Frodsham Solar

Statement of Common Ground with the Environment Agency

PINS Ref: EN010153
Document Ref: EN010153/DR/8.17
Planning Act 2008; and Infrastructure Planning (Applications:
Prescribed Forms and Procedure) Regulations Regulation 5(2)(q)

Revision ~~P01~~P023

**CROSSING CP22 PROPOSED SECTION B-B
ALTERNATE ARRANGEMENT
1:50**

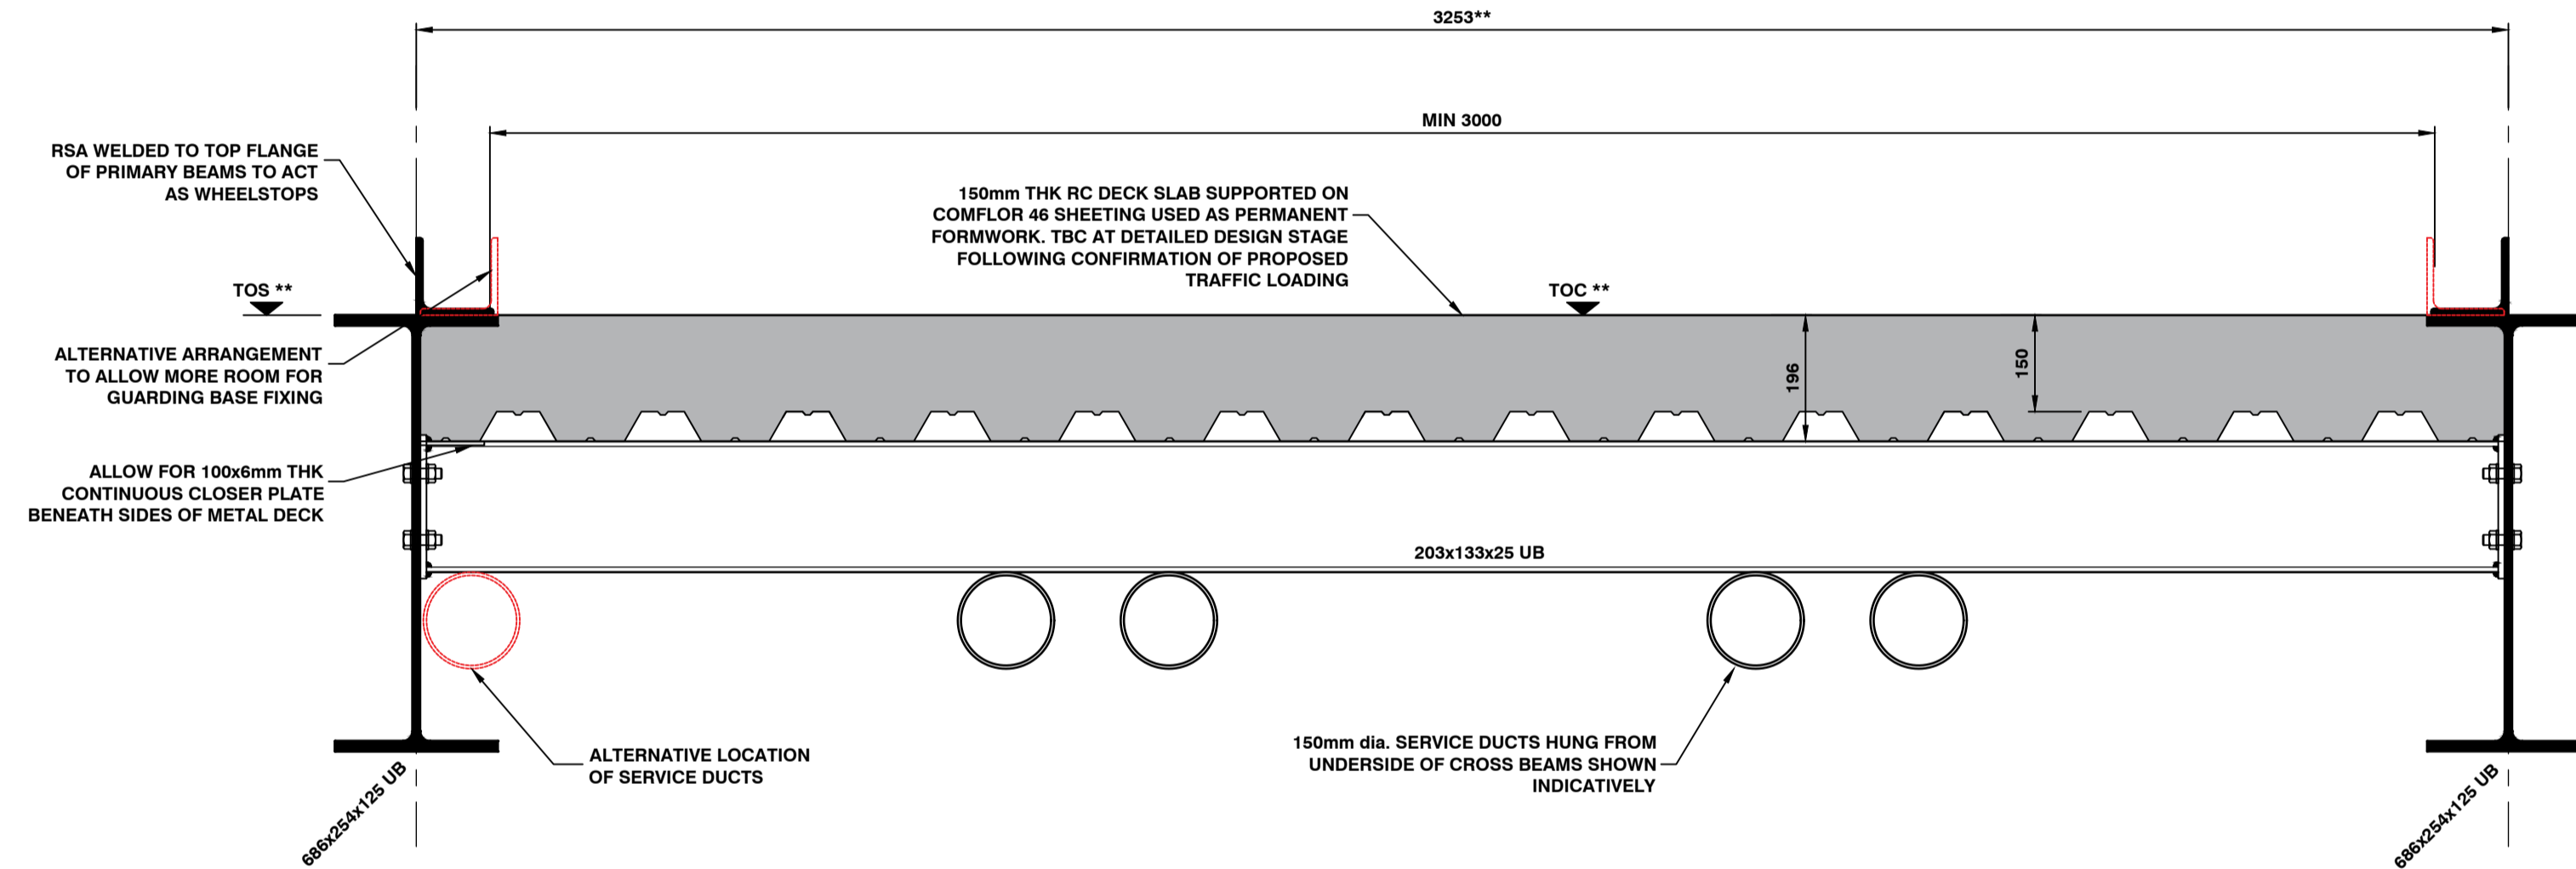
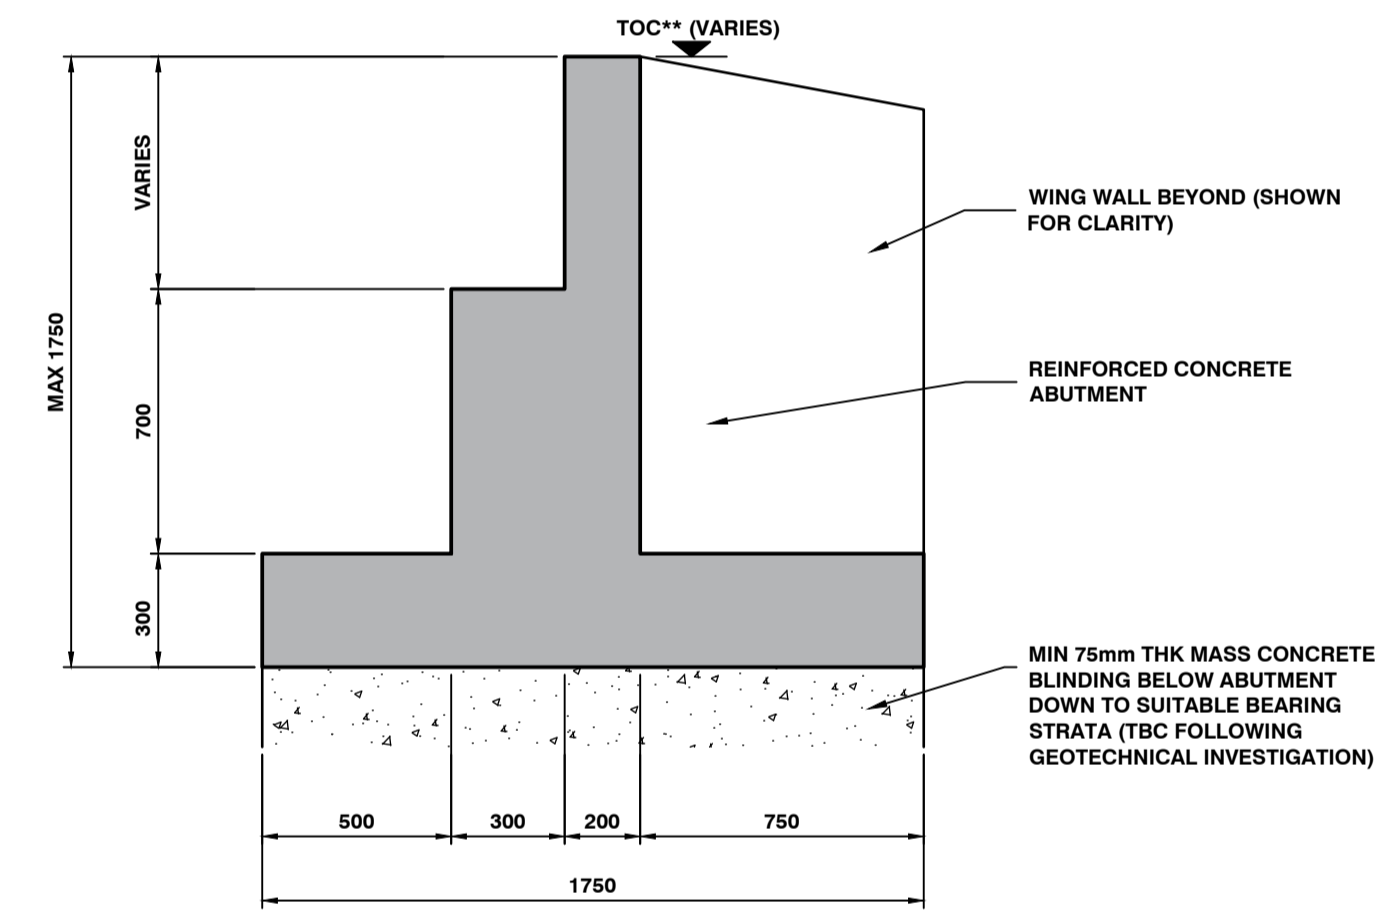
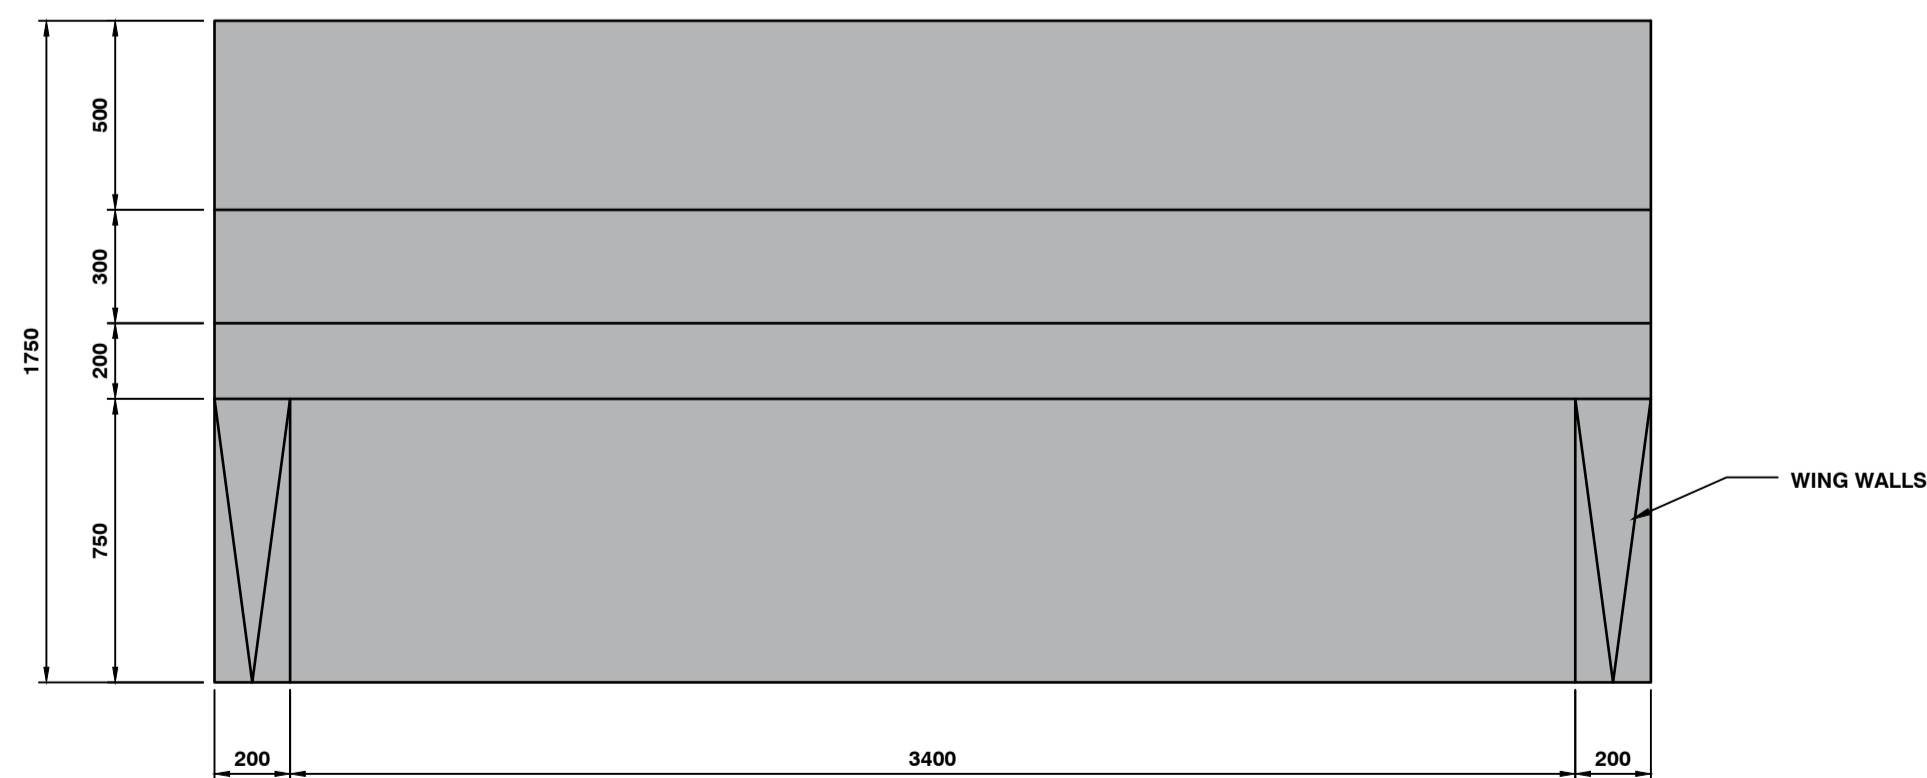
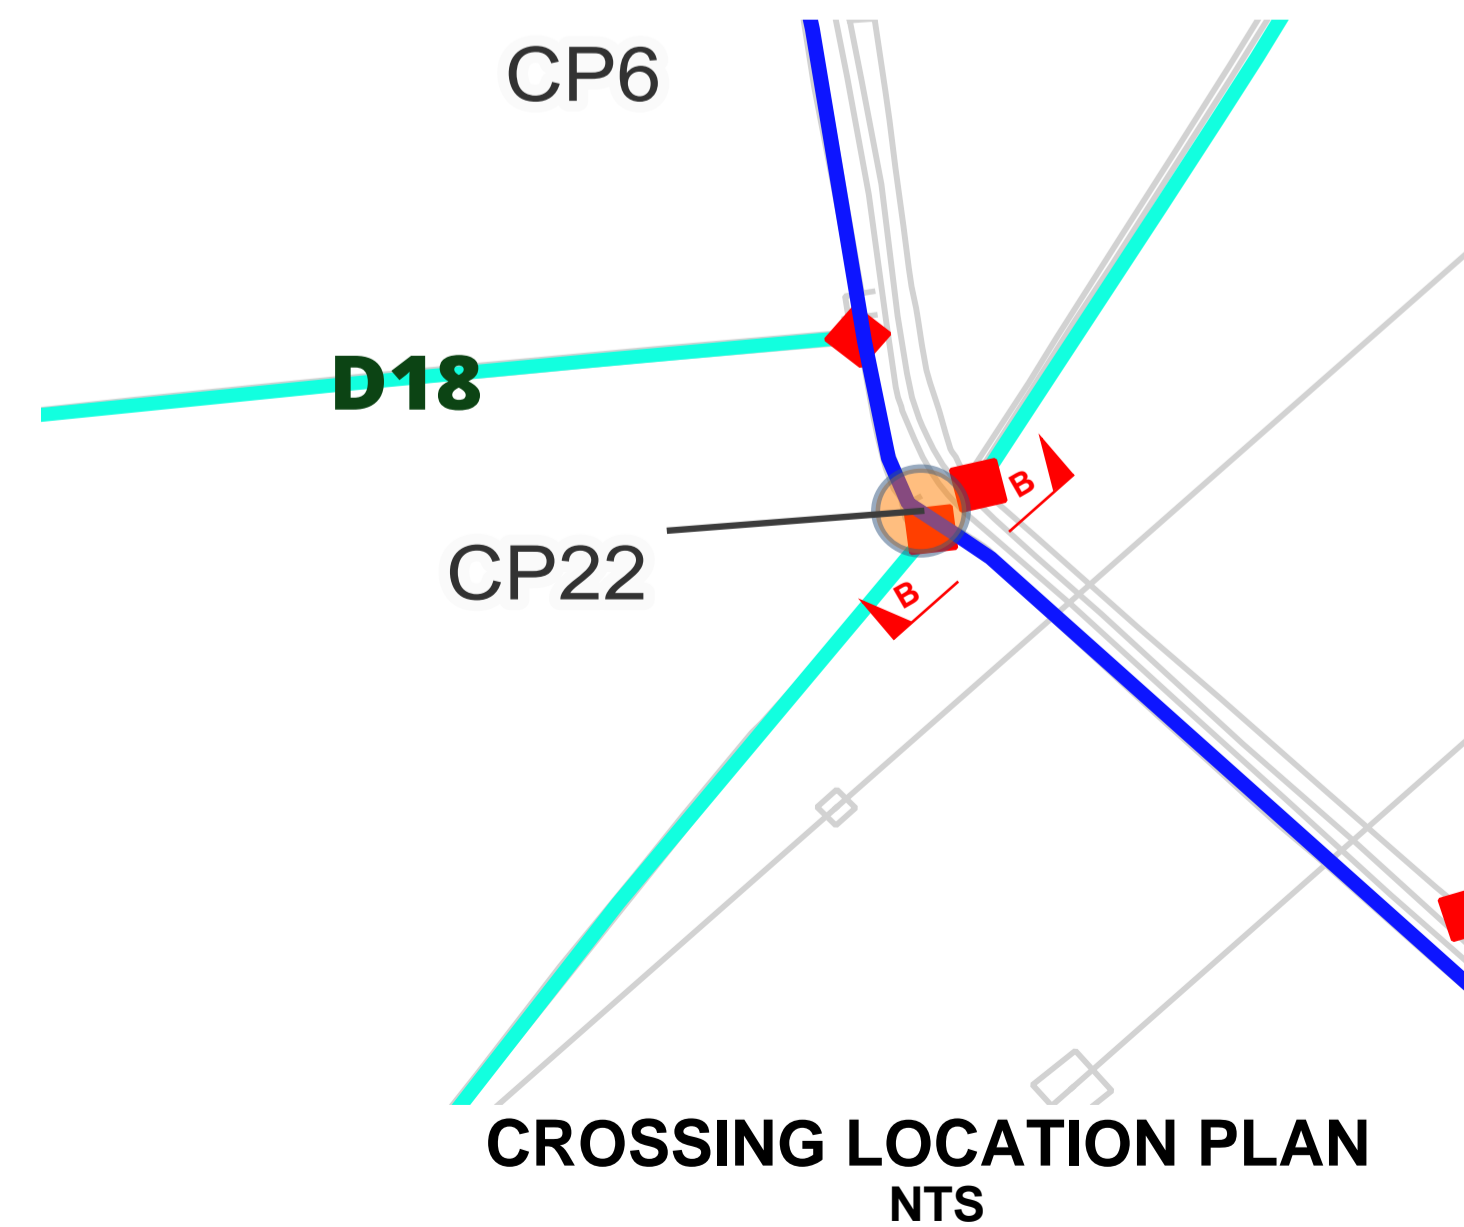
Ref.	Matter	EA Position	Applicant Position	Status
		<p>the mitigation area in Cell 3. Discharges to the Manchester Ship Canal will need to be assessed to ensure suspended solids are not being added to the environment during construction. A Water Discharge Activity Permit will therefore be required.</p> <p>If any abstractions needed for the purpose of firewater do not exceed 20m³ per day, then an abstraction will not be required. If an abstraction of greater than 20m³ is needed, then please contact the Environment Agency for instructions on how to apply for an abstraction licence.</p>	recognised in the Other Consents and Licences Statement (APP-127) .	
Topic(s): Water Quality and Resources, Flood Risk and Drainage, Ecology and Biodiversity				
012	<p>The Applicant's approach to designing watercourse crossings.</p> <p><i>EA Issue ID: EA007</i></p>	<p>The EA has concerns about the position of bridge abutments and soffit levels, and that these will reduce conveyance of water during high flow conditions, preclude access to, and threaten the stability of the riverbanks.</p> <p>The EA request that a soffit level at least 0.6metres is provided from the bank top, as set out in the Standard rules SR2015 No 28 guidance. The EA require a 2m offset for the abutments to ensure that geomorphological processes aren't impacted.</p>	<p>The Applicant has provided the EA with additional technical information including a technical note and cross-sections, and has undertaken a site visit alongside the EA to discuss the issue.</p> <p>The Main River bridge crossings CP14 and CP17 will be constructed to provide a 600mm freeboard between the bridge soffit and top bank level, and abutments set 2m back from the bank, in line with the EA's requests. This change has not been made at CP22, as there is insufficient space to</p>	<p>Under discussion</p> <p>EA Agreed on design of CP14 and CP17 – still reviewing CP22.</p>

Ref.	Matter	EA Position	Applicant Position	Status
		<p>The EA has requested that the Applicant demonstrates that 300mm freeboard form the soffit of the bridge to design flood levels would be provided at CP22.</p>	<p>enable a 600mm freeboard. However, it was agreed with the EA that the reduced freeboard provided for by the Applicant in the design would still provide betterment at this existing crossing by providing a new clear span bridge which is currently culverted.</p> <p>Schedule 23 of the draft DCO provides protective provisions for the protection of the Environment Agency. These protective provisions require the Applicant to submit and obtain approval of the bridge crossings (as a specified work) prior to the commencement of their construction. At present the EA have not agreed to the protective provisions.</p> <p>-Table 5-4 of the oCEMP was revised at Procedural Deadline B (REP2-015) to include the above design requirements for the main river bridges such that the above design parameters are secured by the DCO.</p> <p>The Applicant understands this matter is now resolved and can be marked as agreed.</p> <p>The Applicant is preparing additional drawings relating to CP22 to try and</p>

Ref.	Matter	EA Position	Applicant Position	Status
			reach an agreed position on the bridge design.	
12(a)	The Applicant's approach to the design of the BESS Compound and Substation	The EA raised a number of points relating to the design of the BESS and Substation Compound within Appenix Appendix B of Comments on Relevant Representations and any additional submissions [REP1-050].	<p>The Applicant has responded to the points raised by the EA and has made a number of revisions to the Outline Battery Safety Management Plan, the oCEMP, oOEMP and oDEMP. The Applicant therefore considers that the concerns of the EA have been addressed.</p> <p>The Applicant acknowledges that batteries can cause chemical pollution and present a fire risk if not managed appropriately that could cause a decrease in water quality if any surface runoff becomes contaminated.</p> <p>The Outline Battery Safety Management Plan has been amended to set out that if a battery storage area is provided external to the BESS compound, that it shall be impermeable, covered and bunded. Any battery storage areas will be confirmed as part of the detailed design.</p>	Matter Agreed (subject to EA review of Deadline 35 submissions)
